RE: *Grading and Drainage Plan for Les File Drywall (G15/D51) (PWDN 990159)*
Engineer's Stamp Dated 8/4/99.

August 16, 1999

RE: *Grading and Drainage Plan for Les File Drywall (G15/D51) (PWDN 990159)*
Submitted for Building Permit Approval, Engineer's Stamp Dated 8/4/99.

**DRAINAGE & GRADING PLAN
FOR
LES FILE DRYWALL
BERNALILLO COUNTY, NEW MEXICO**

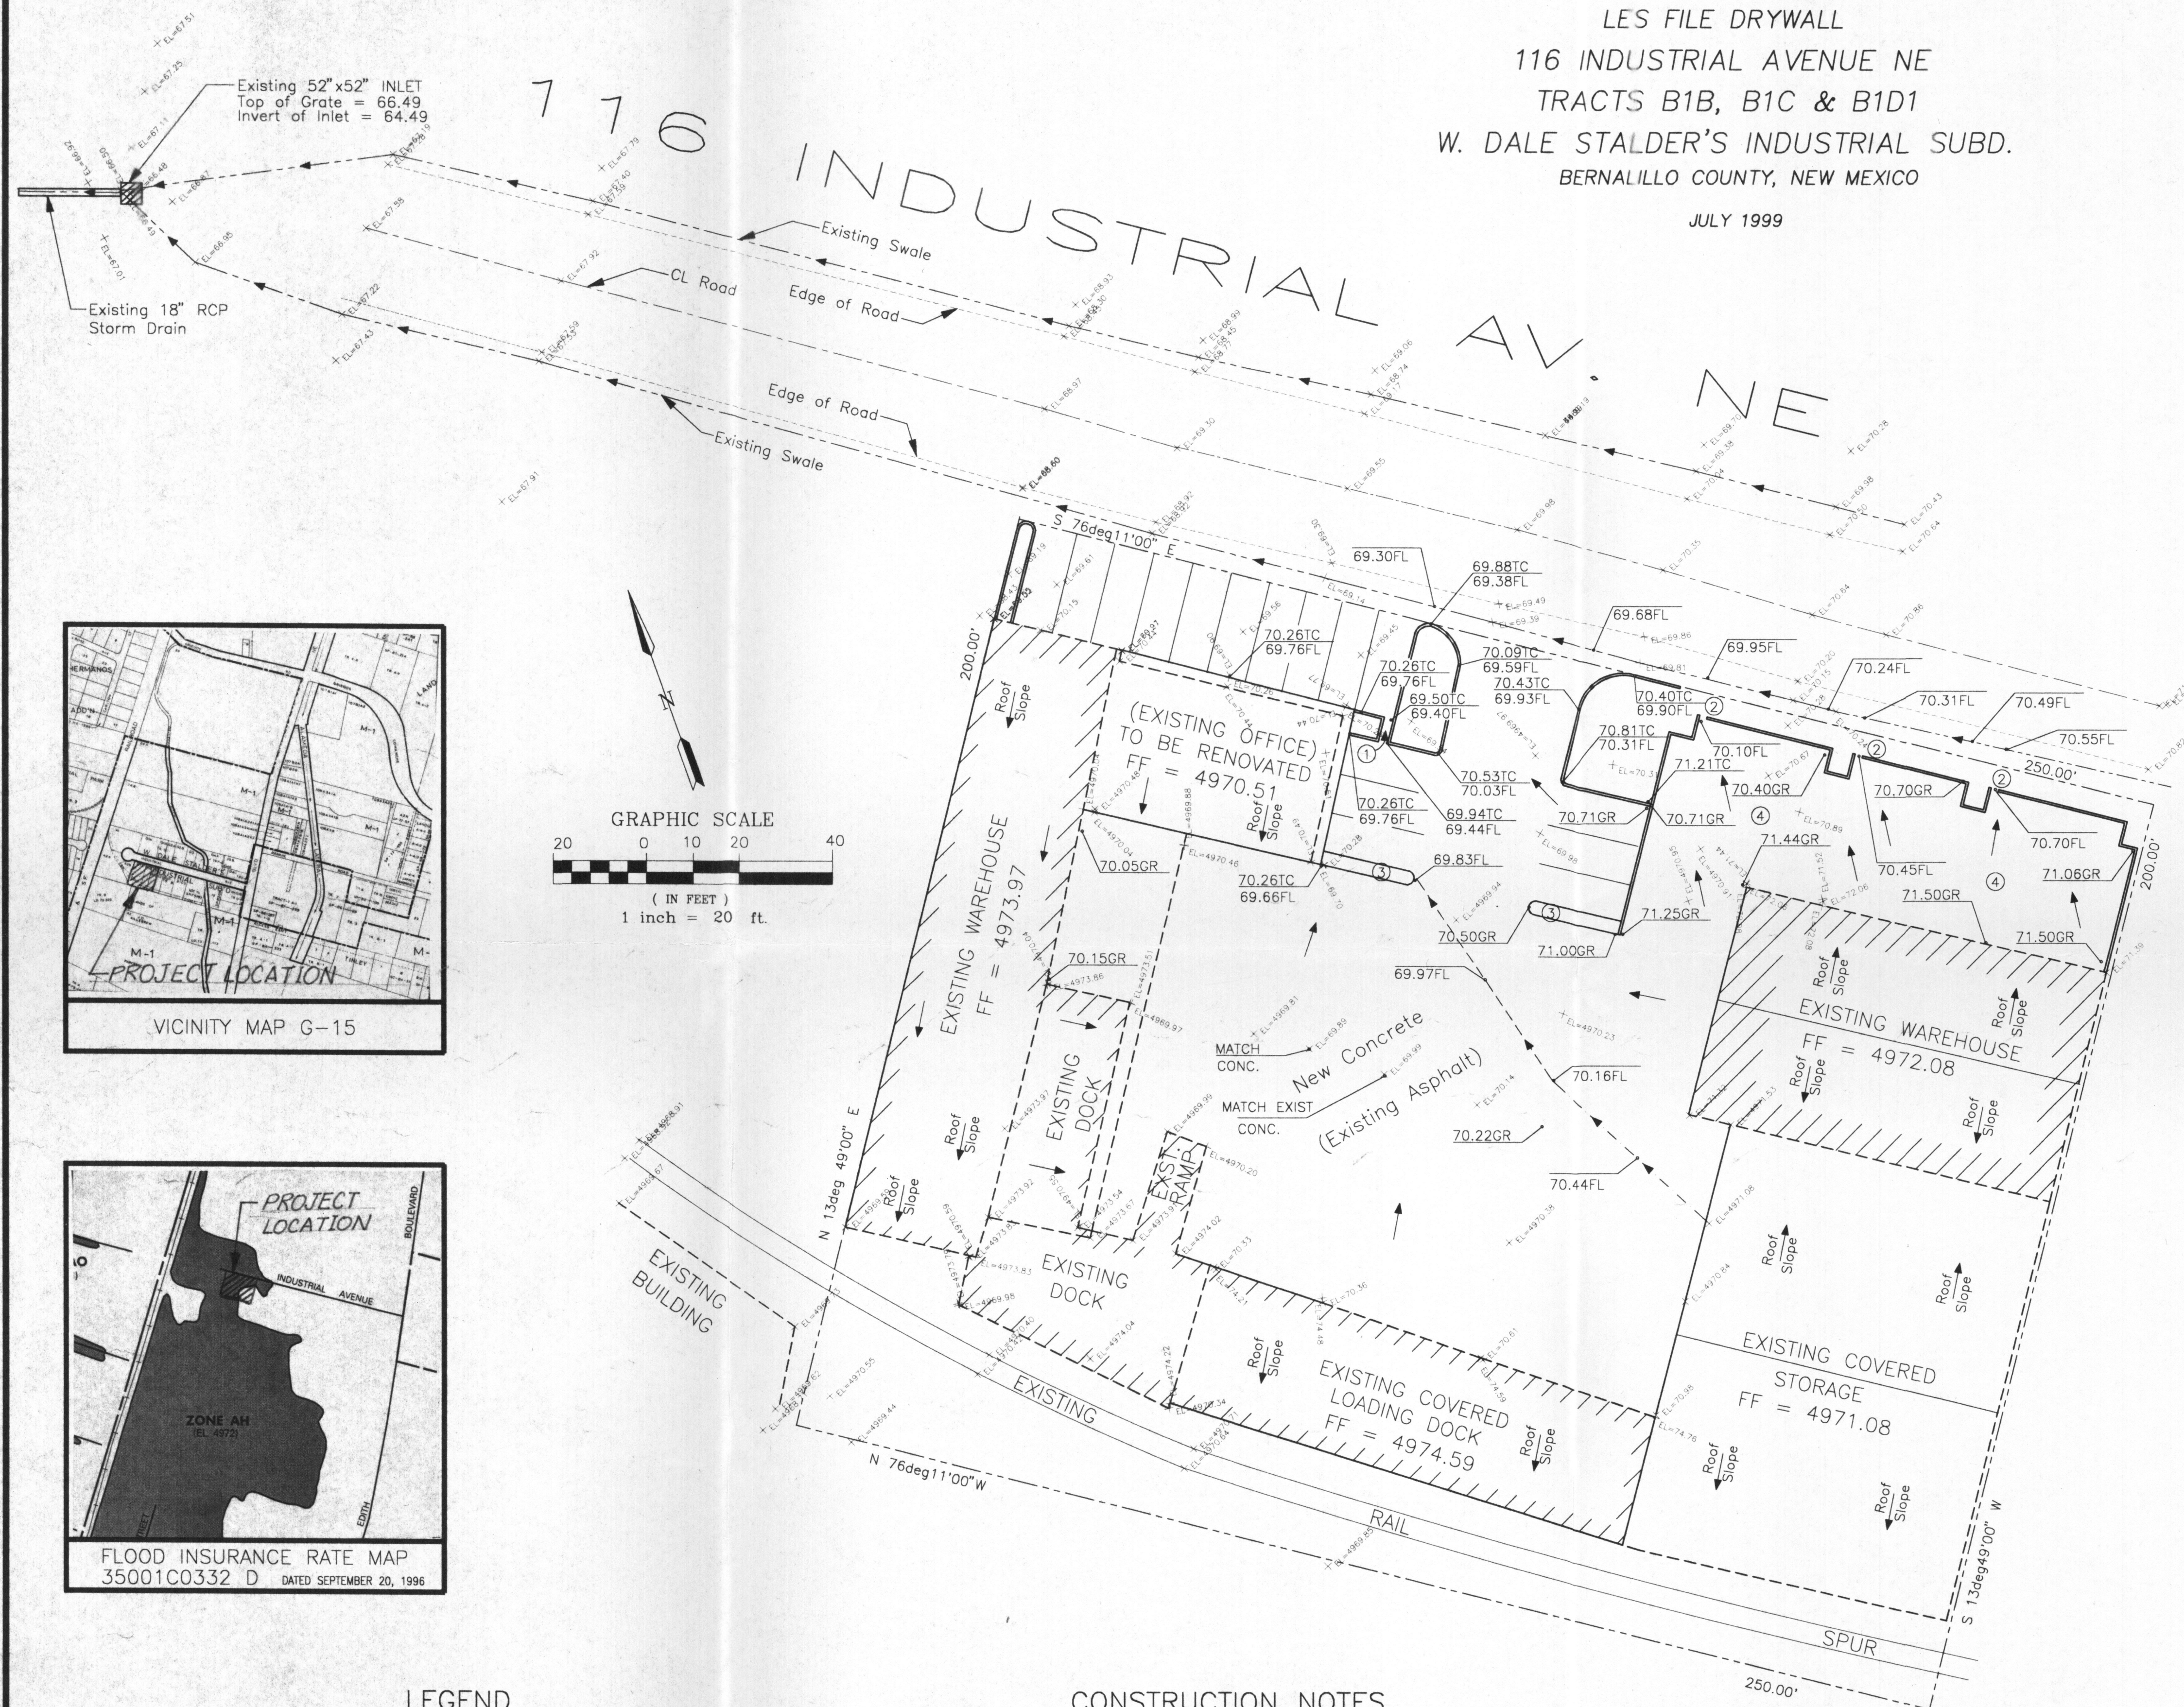
1. Please show the floodplain limits on the plan.
2. Show the drainage basin for the existing inlet on Industrial Avenue. Provide the runoff rate and the inlet capacity calculations. Where is the existing ponding area with respect to the site? Does the existing pond have capacity for the drainage basin?
3. This plan should reference the Master Drainage plan for the Edith Boulevard widening project regarding the proposed future improvements. What is the status of this project? Will the County obtain a Letter of Map Revision to remove this floodplain after the Edith project is complete?
